# CITY OF PORTLAND, MAINE

December 23<sup>rd</sup>, 2013

**Project Name:** Munjoy Heights  
Six new buildings comprising 29 residential townhouses; one existing house on reconfigured lot  
**Project ID:** 2013-228  
**Project Address:** 79 Walnut Street  
**CBL:** 12-F-2 (part), F-4, F-7, F-18; 12-G-6; 12-H-1, H-3, H-5, H-7, H-9, H-13, H-17, H-22  
**Applicant:** Jonathan Culley, Redfern Munjoy LLC  
**Planner:** Jean Fraser

DRAWING NO. **C-31**

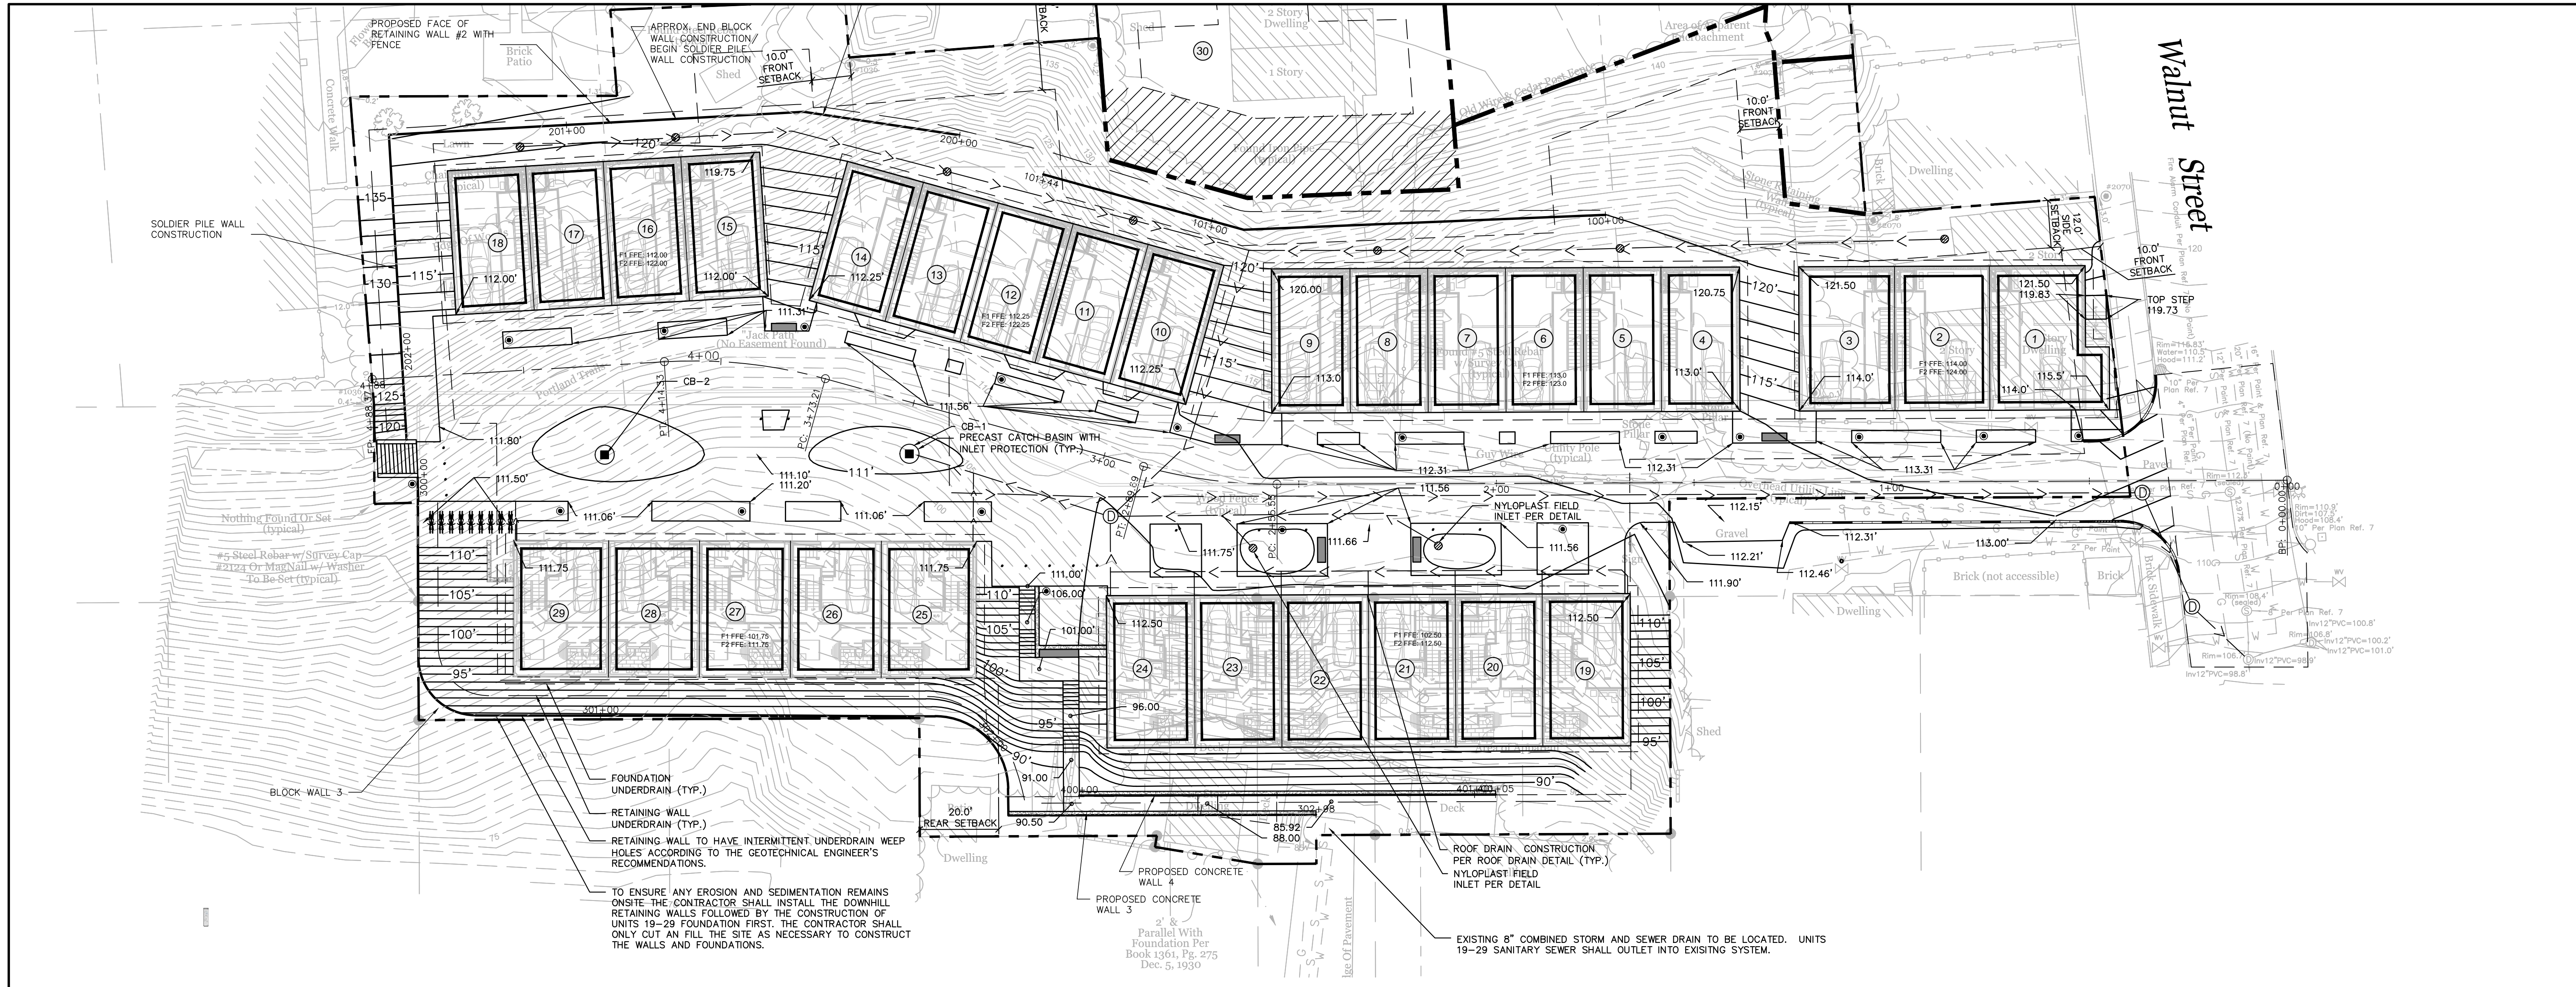
- vi. The applicant has noted on Plans Sheet C-32 & C-33 that Summit Engineering Services in coordination with Structural Integrity Consulting Engineers, Inc shall provide the retaining wall design, global stability analysis, and the design of the temporary soil restraint measures, as required. The referenced retaining wall designs shall be completed, stamped by a professional engineer, and submitted to the City of Portland Inspections Department and Planning Authority as part of the Building Permit process prior to construction of any retaining walls; and
